Your ref:
Our ref: 22/01987/FM
Please ask for: Miss Sandra Homcenko
Direct dial: 01553 616824
E-mail: borough.planning@west-norfolk.gov.uk

Details: **Installation, operation, and decommissioning of solar farm comprising an array of ground mounted solar PV panels and battery storage system with associated infrastructure including inverters and a substation compound as well as fencing, security cameras, cabling and bio diversity enhancement measures. at Land SE of Poplar Farm Harps Hall Road Walton Highway Wisbech Norfolk**

I have received a planning application as detailed above but cannot process it until I receive some more information:

| Proposed Site Plan | |

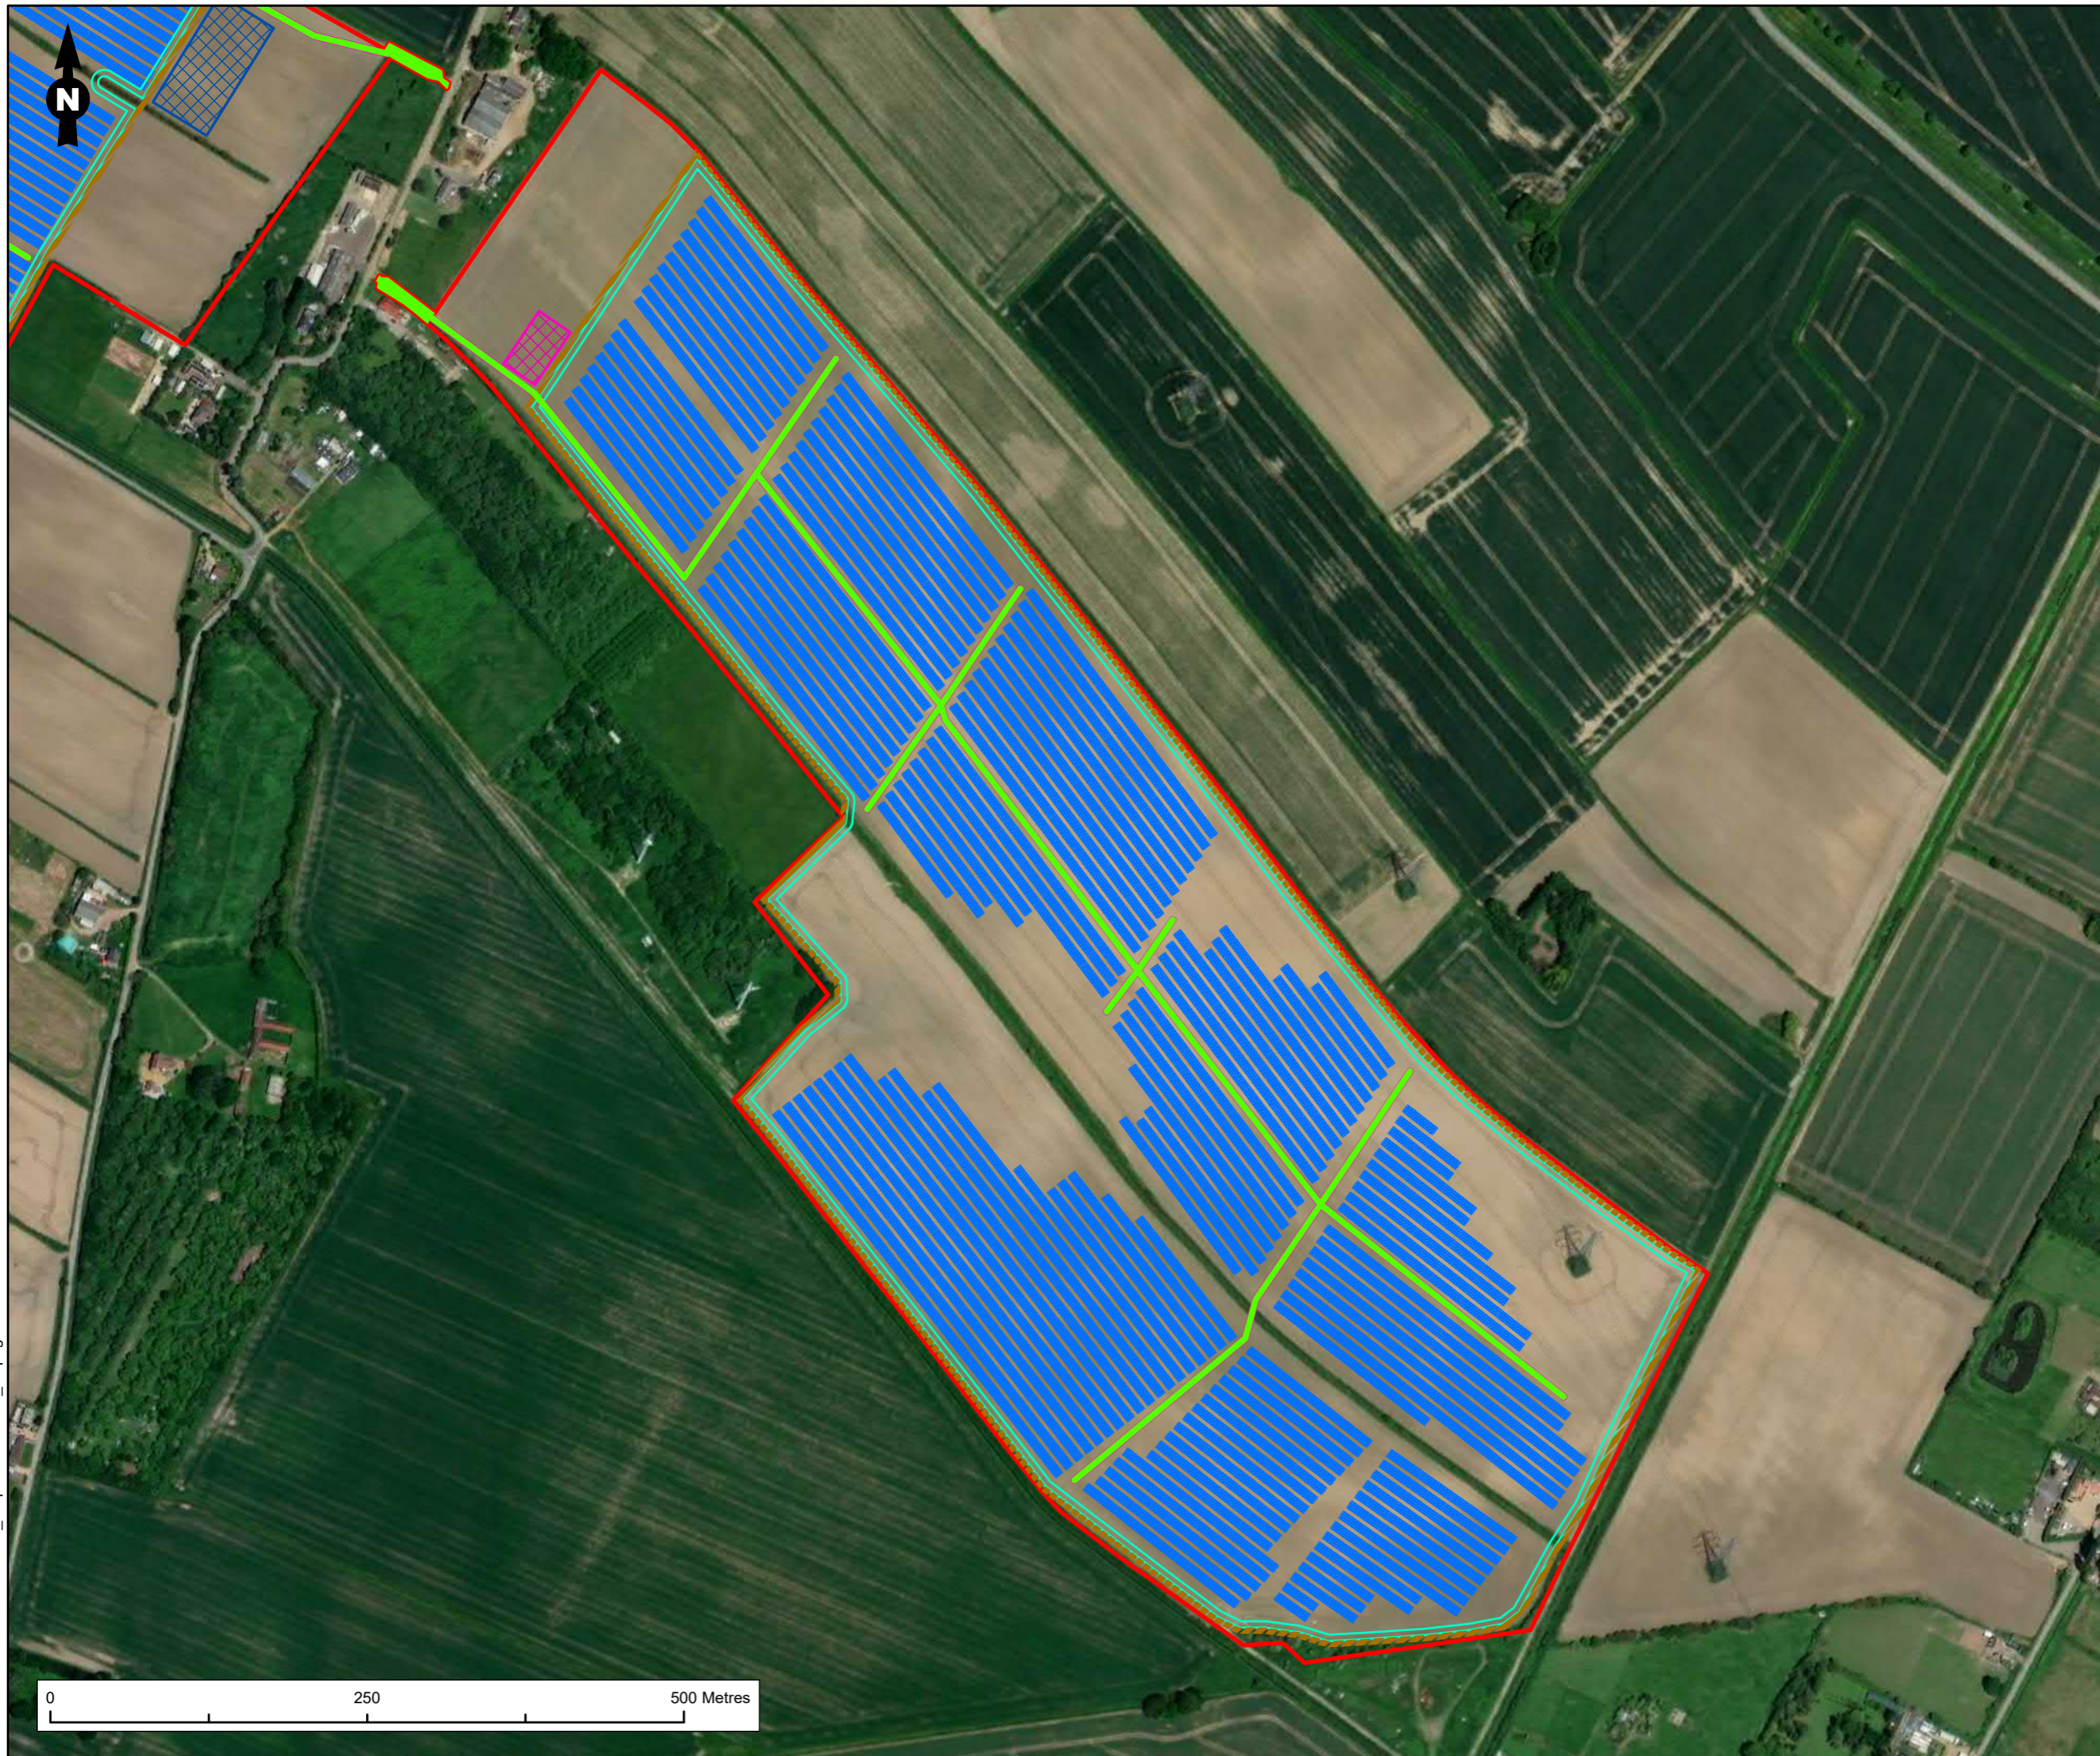
1. Apologies however we cannot accept plans that are not to scale. Please provide drawings: 2.3, 2.4, 2.5 and 2.6 to a recognisable scale.
2. Apologies, however we cannot accept plan to scale of 1:4000. Please amend the drawings 2.1(Existing Site plan), 2.1b (Existing Site plan) and 2.2a (Proposed Site plan) to a scale of 1:5000
